## DEVELOPMENT FACILITATION TEAM

### Planning - Case Comments

**Project Number:** PR-2023-009368

**Project Name:** Farolito Senior Community

SHEET NO
SDP 4.2

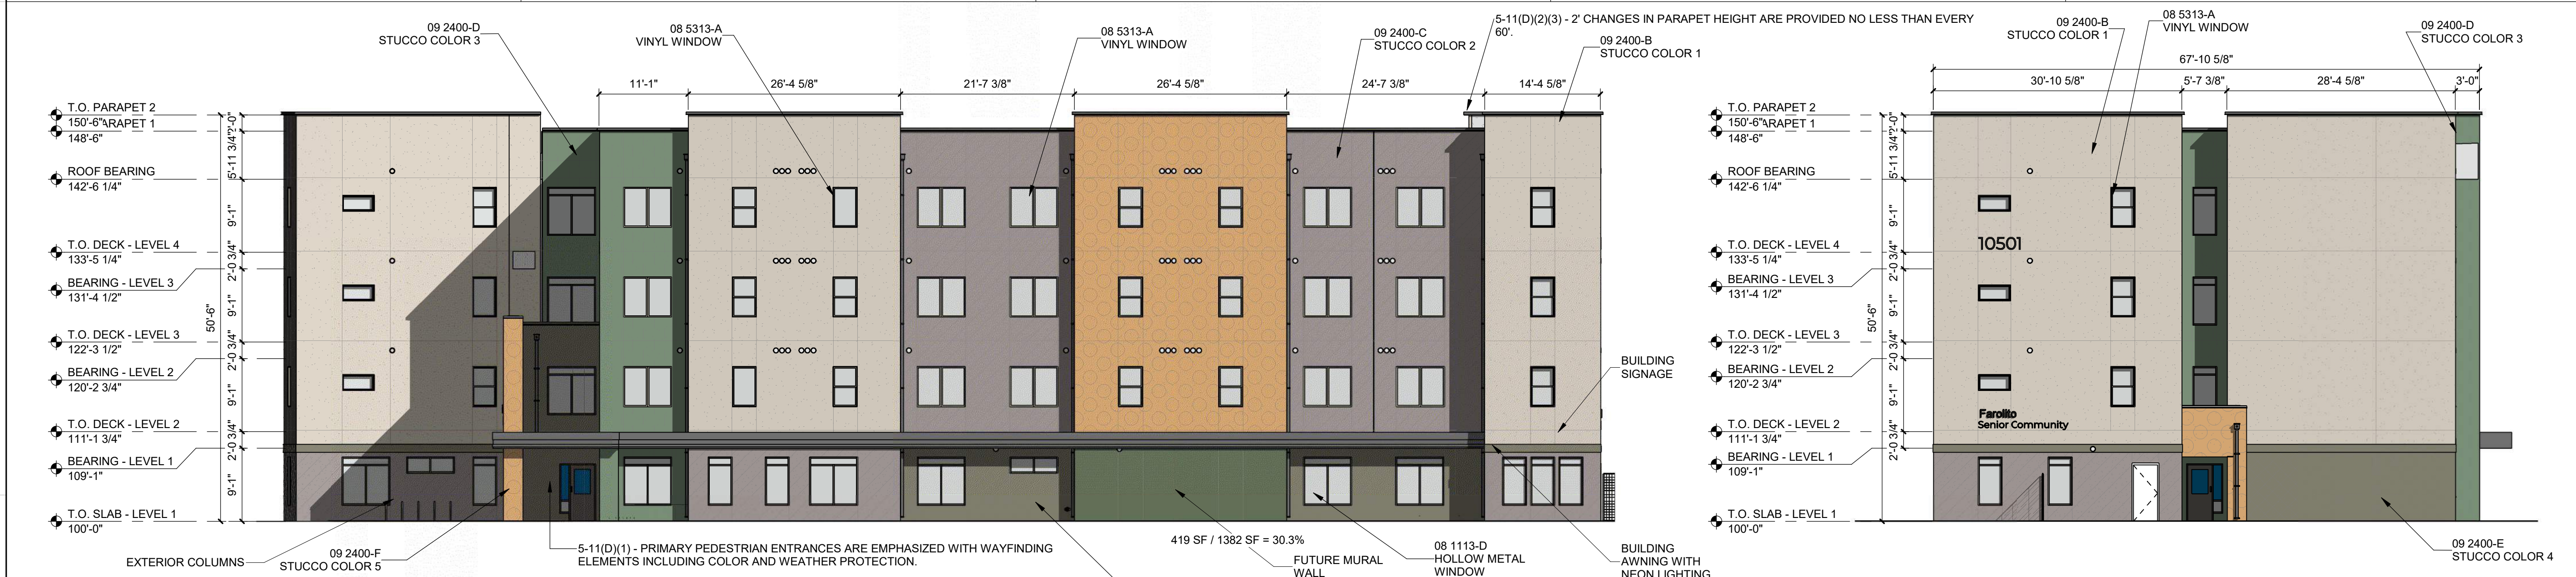
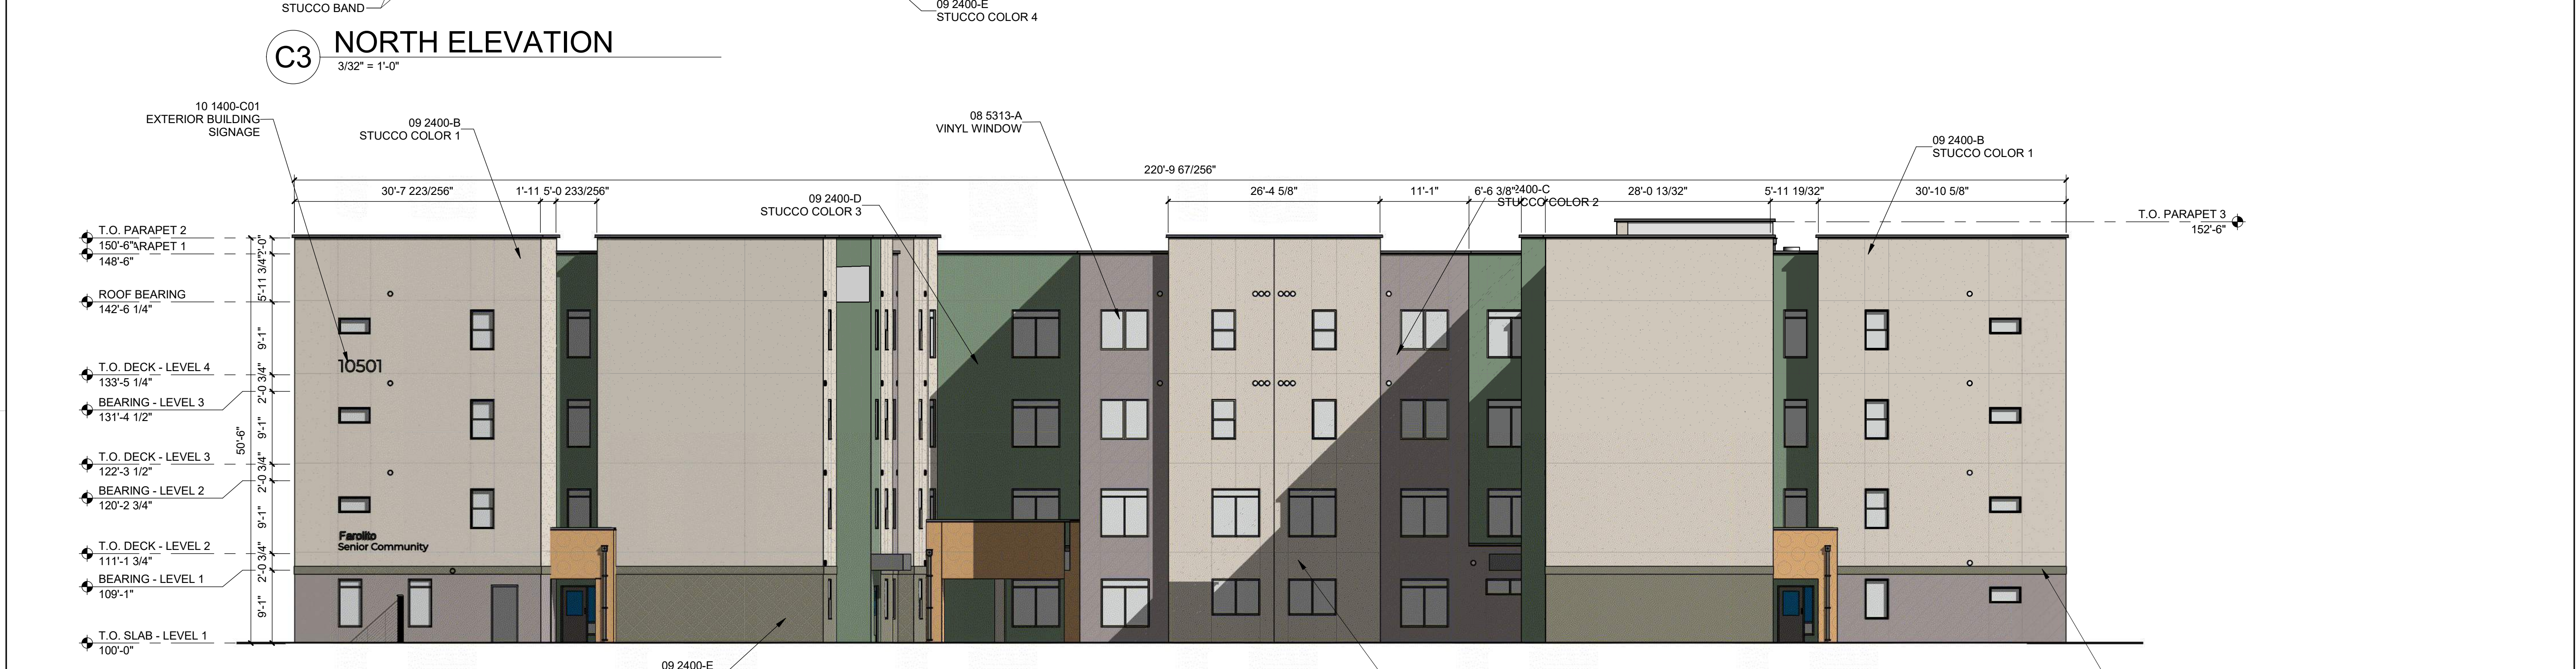
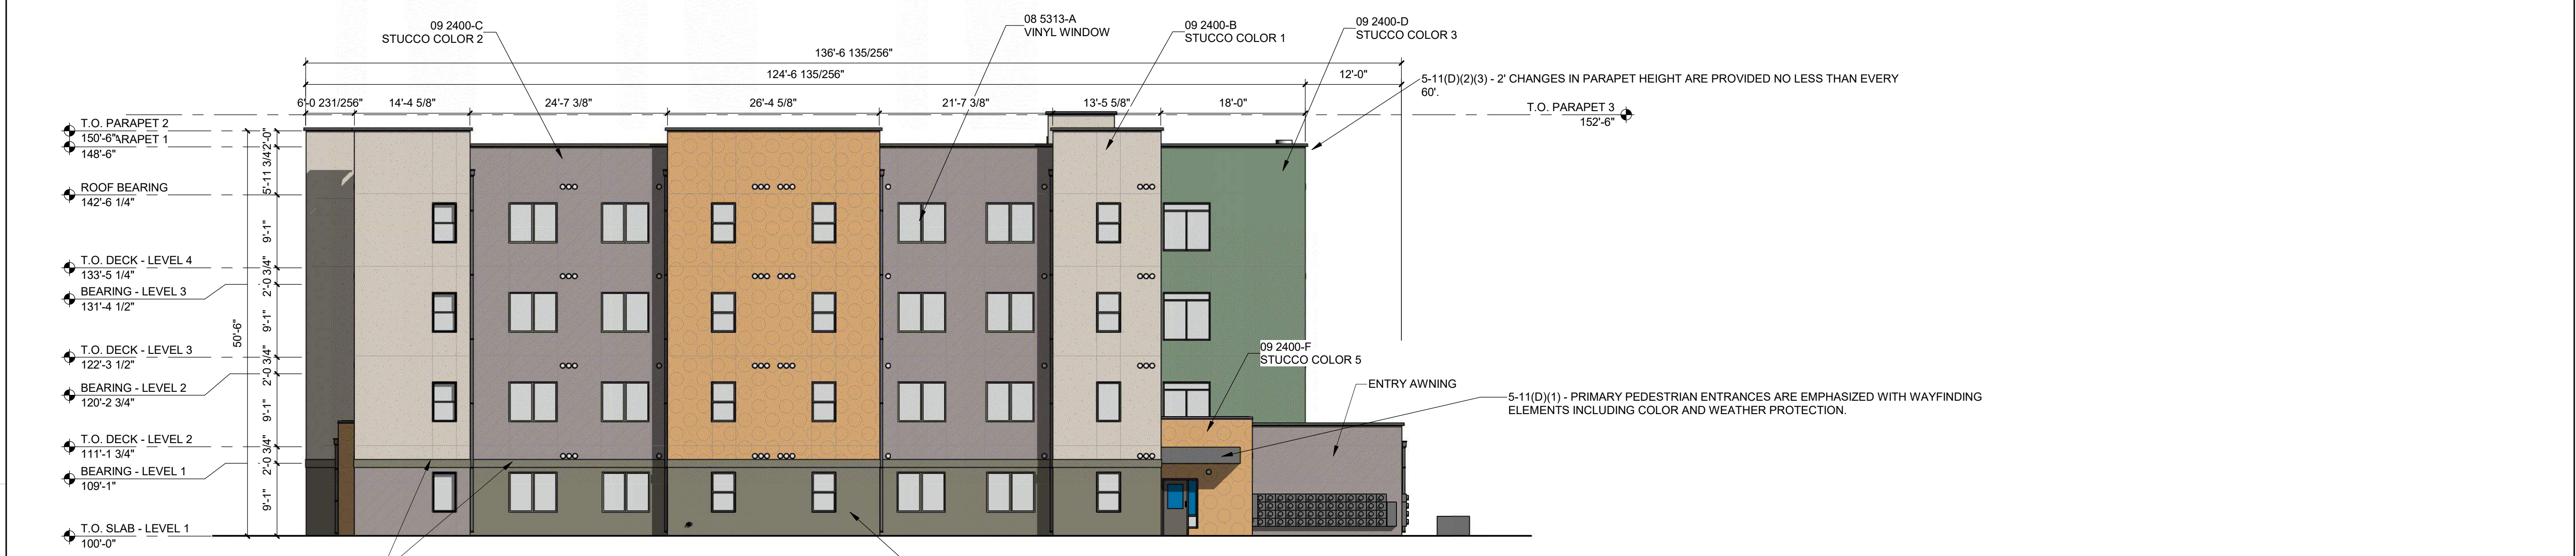
**Please articulate how the facade design meets item number 2. This is workforce housing.**

**Design complies with this code. Please provide an explanation for the façade color selection. If the intent is to mimic the Luminaria project across the street, please**

1. The ground floor of each street-facing façade shall contain a minimum of 20 percent of its surfaces in transparent windows and/or doors.
2. Windows on the upper floors shall be recessed or projected not less than 2 inches and/or shall be surrounded by a window casing or frame not less than 2 inches wide, except for portions of the façade that are storefront window systems or curtain walls. **Workforce housing is exempt from this requirement.**

~~consider providing more non-grey colors on the façade.~~
